Development Facilitation Team (DFT) – Review Comments

Project No: PR-2024-009956 **Date: 2/12/2025** **Agenda Item: #7** **Zone Atlas Page: M-9**
Legal Description: 1D, Town of Atrisco Grant, projected section 33 township 10 North range 2 East.
Request: Proposed site improvements for a new tenant building with a Taco Bell quick-service restaurant with accessory drive-thru on the end cap.
Location: 1115 Snow Vista Blvd between Sage Rd/De Vargas Rd and Benavides Rd.

Application For: SI-2024-01475 – SITE PLAN DFT

## LAYOUT AND MATERIALS PLAN

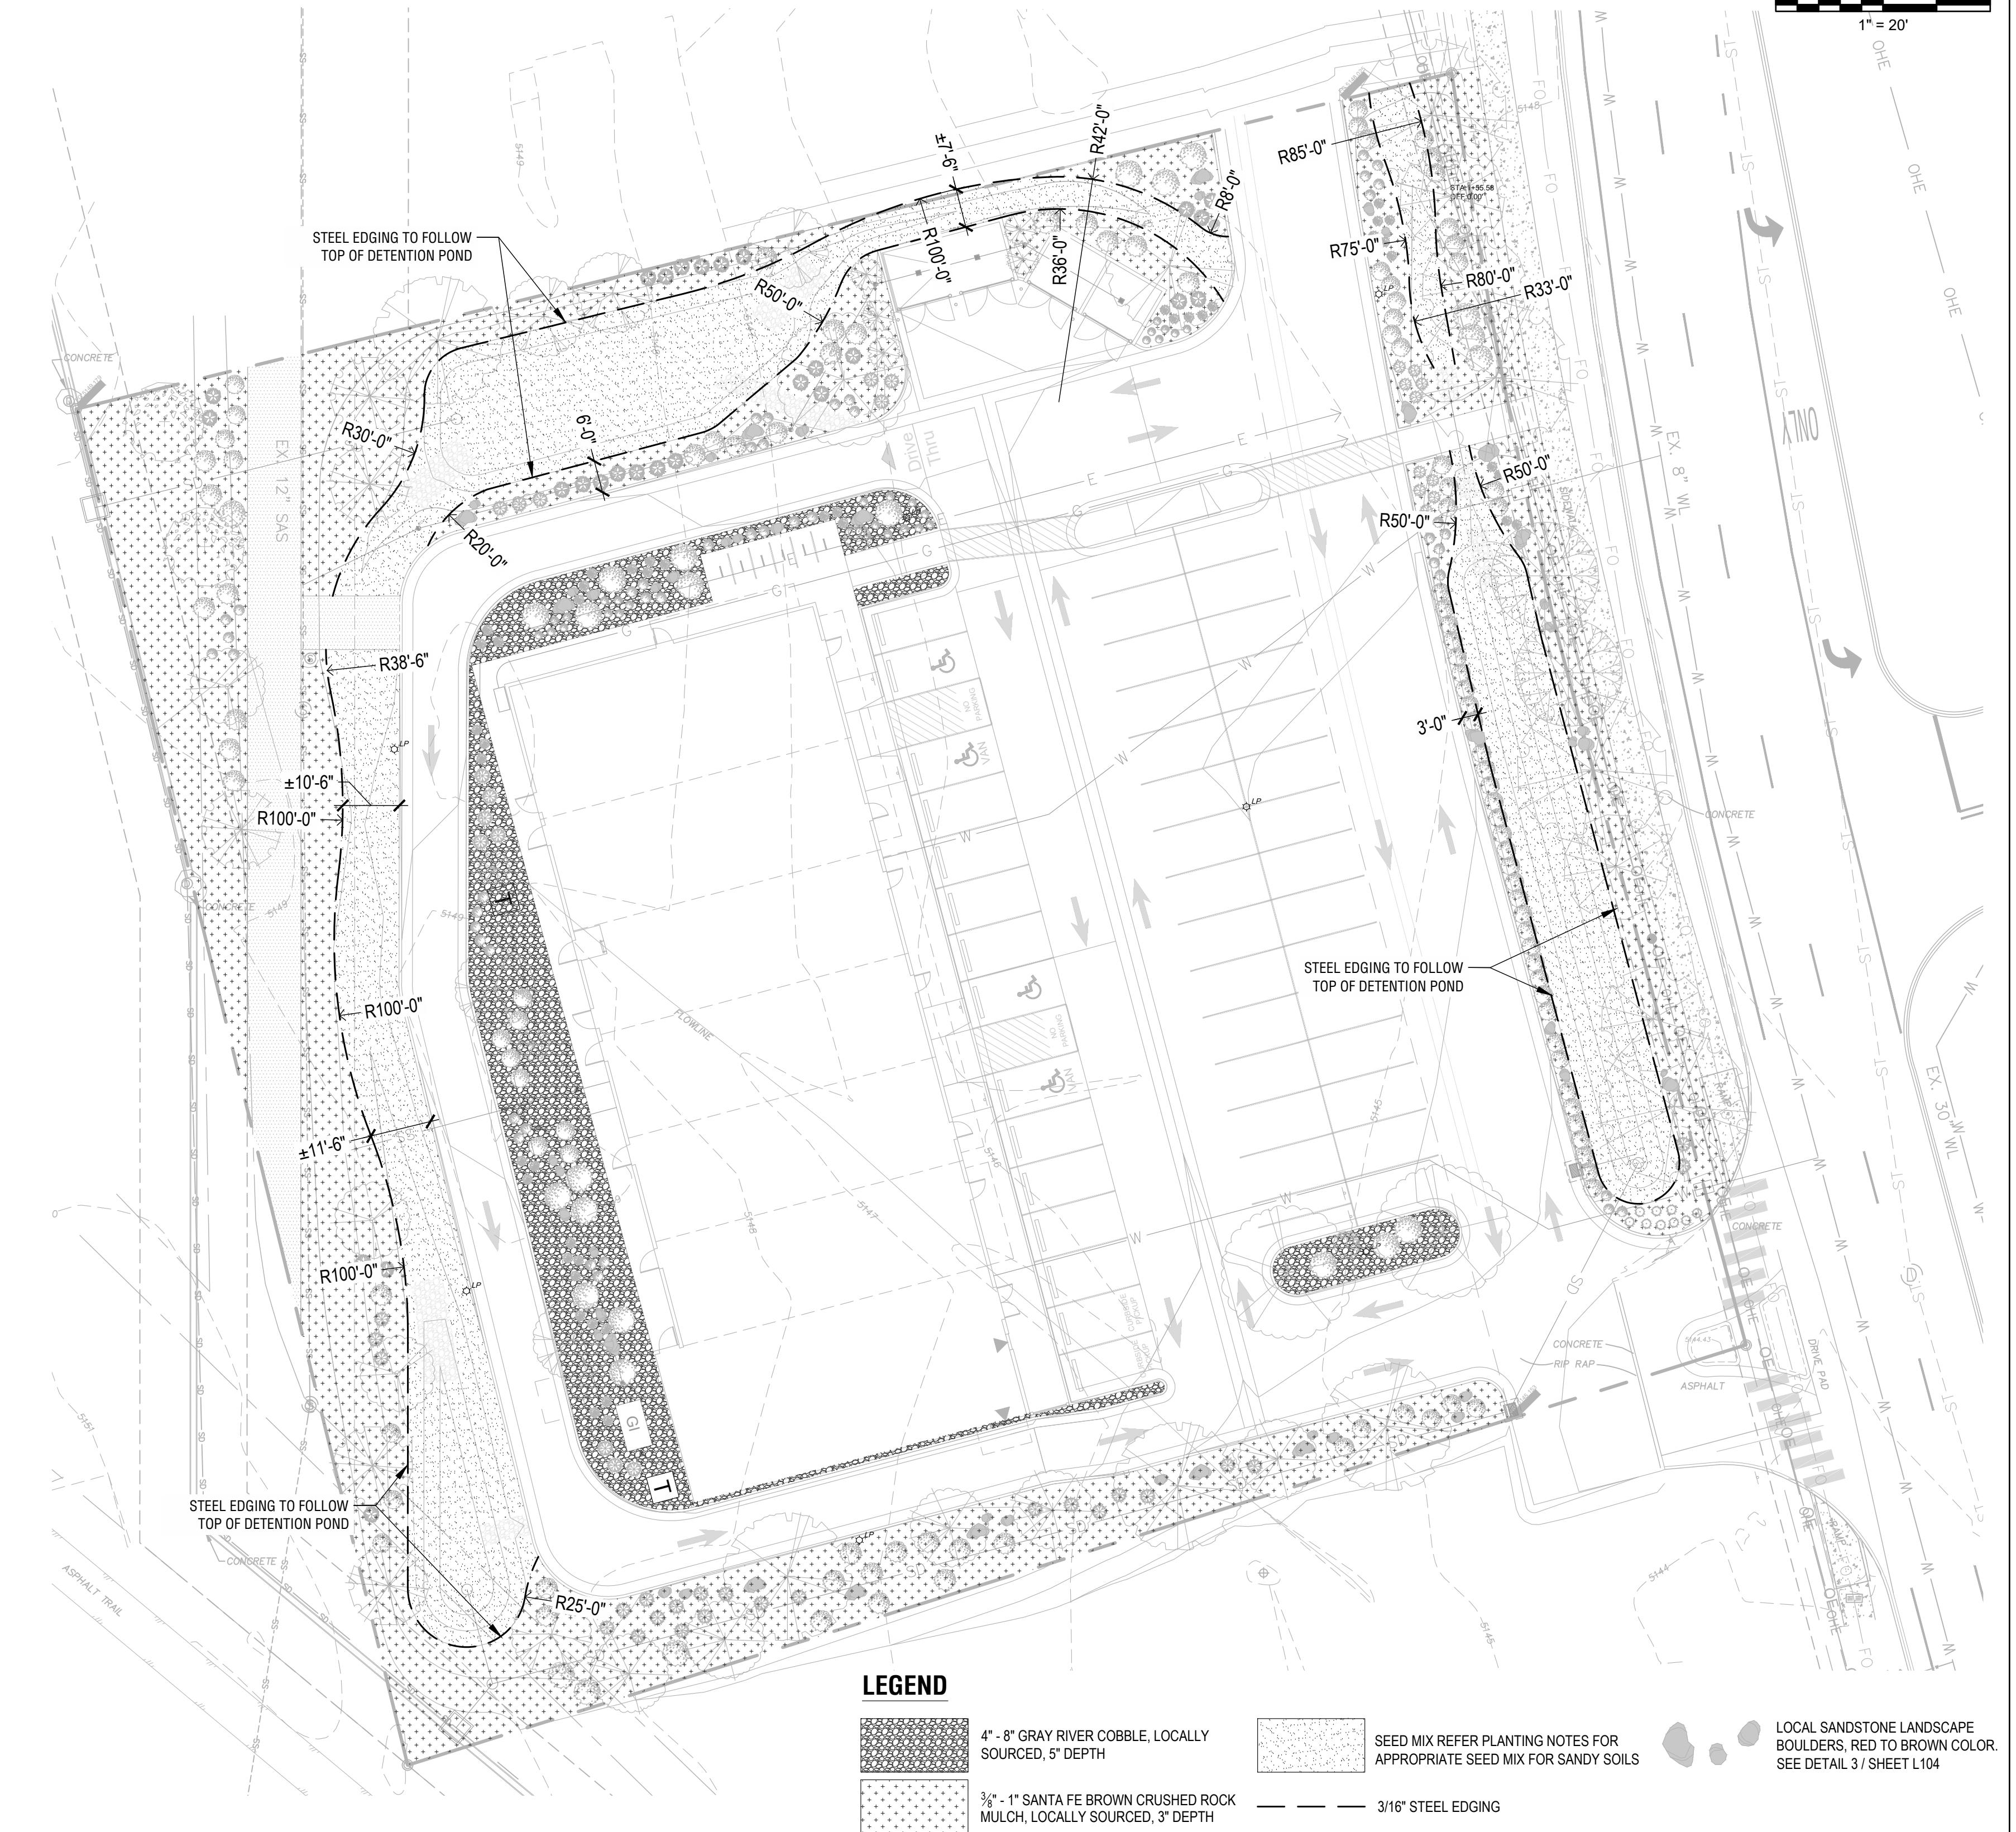
- Per 5-6(C)(10)(f), trees shall not be planted near existing or proposed street light poles. [confirm compliance with this code. Locations of light poles to be shown on the plan.](#)
[Locations of light poles are shown on plan](#)

1 TYPICAL TREE PLANTING  
NTS

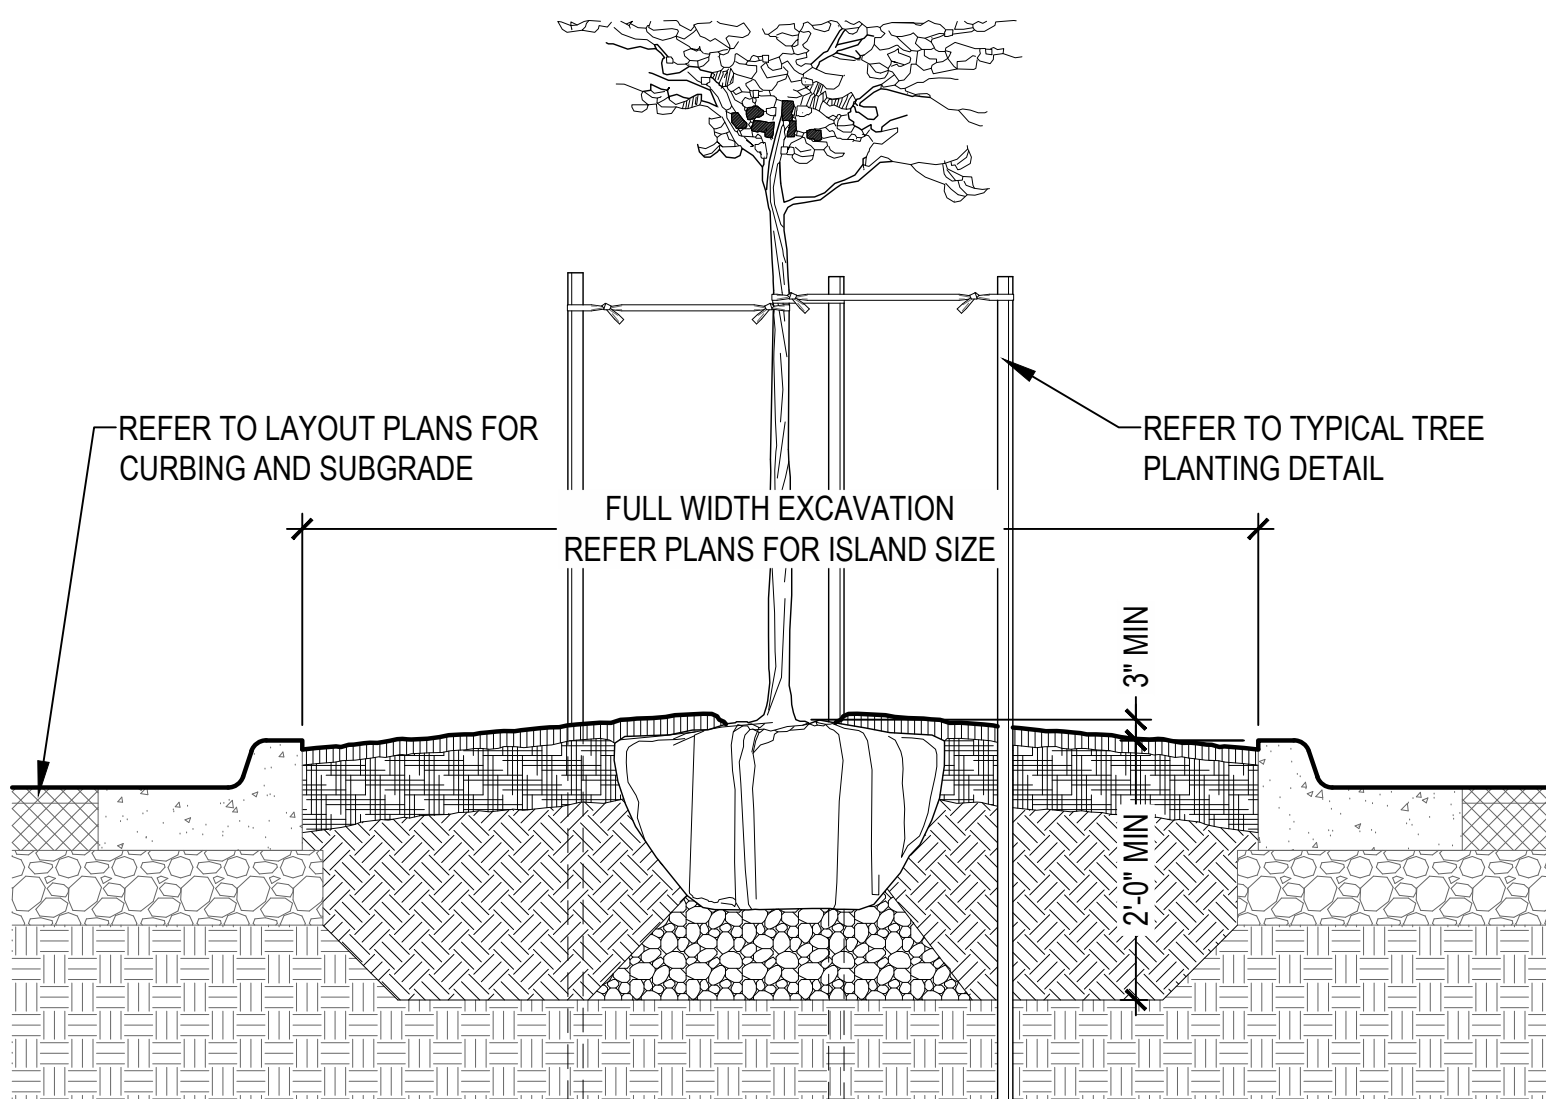
- Per 5-6(C)(5)(e) Organic mulch is required as ground cover under trees within a 5-foot radius around the tree trunk, but not directly against the trunk. In these areas, weed barrier fabric is prohibited. [The 5' radius organic mulch must be shown and called out on all tree planting details.](#) Please see the figure below from the IDO 5-6(C)(5)(e) for more clarification.

[5' Radius note previously included on standard tree detail](#)
